**KIRKLEES METROPOLITAN COUNCIL  
INVESTMENT & REGENERATION SERVICE**

**DELEGATED DECISION TO DETERMINE PLANNING APPLICATIONS**

Reference No:	<b>2024/62/90342/W</b>
Site Address:	8, Boulder Gate, Marsden, Huddersfield, HD7 6LJ
Description:	Erection of single storey rear extension with roof terrace above, external alterations and extension of existing garage
Recommending Officer:	Lucy Taylor

## **Officer Report.**

Job No: 02223	Drawing No: 02223/PP/05/R01
------------------	-----------------------------------

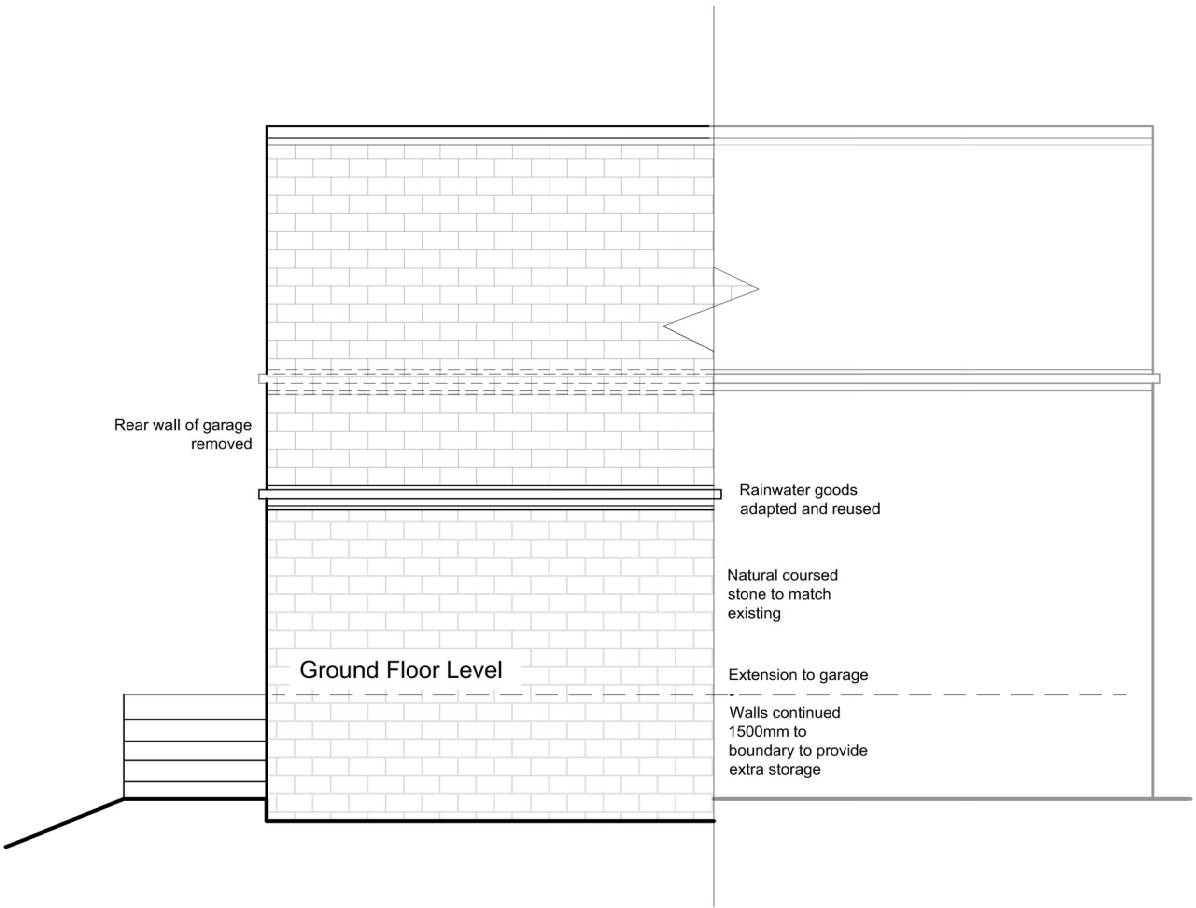
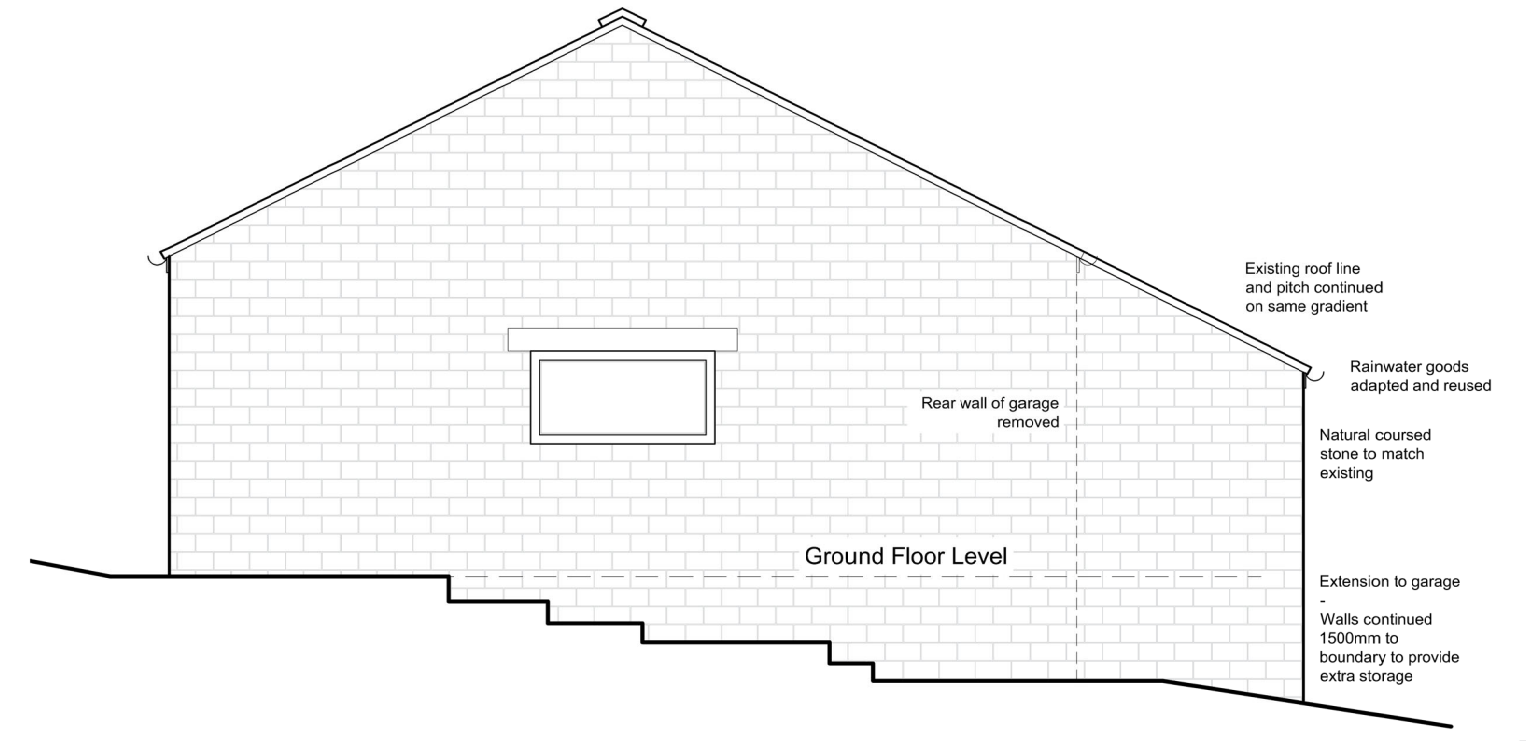
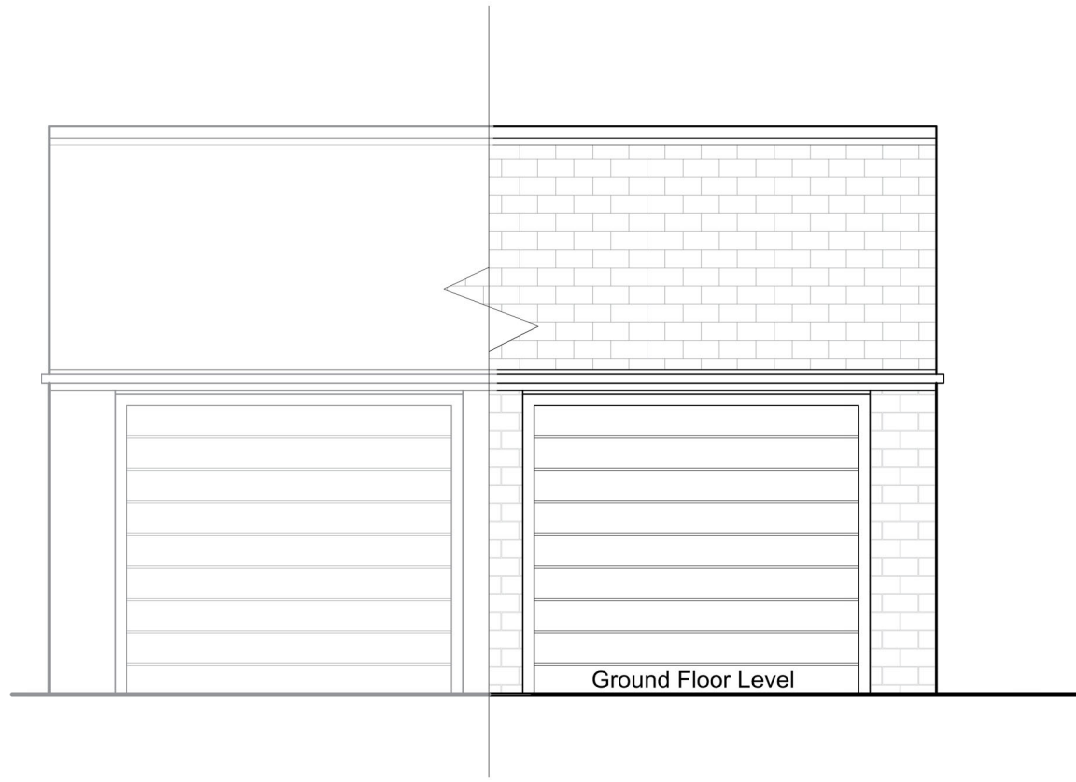
The garage extension would project 3 metres from the rear of the existing garage. The width of the garage extension would be 3 metres. The maximum height of the garage extension would be 4.4 metres, with an eaves height of 2.2 metres.

The walls of the garage would be faced in coursed stone and the roof of the garage extension would be infilled with concrete tiles.

The proposed garage extension would not result in any undue impacts of overbearing and/or overshadowing to neighbouring properties. Whilst it would be extended to the boundary of land adjoining with Steep Farm, it is to be sited adjacent to the rear garden amenity space, with vegetative boundary

treatment present. In addition, the garage extension is to have a low eaves height of 2.2 metres and no glazing is proposed to the rear elevation of the garage extension.

3. The external walls of the extensions hereby approved, and the roofing materials of the garage extension hereby approved shall in all respects match those used in the construction of the existing building to which the extension relates and be thereafter retained.
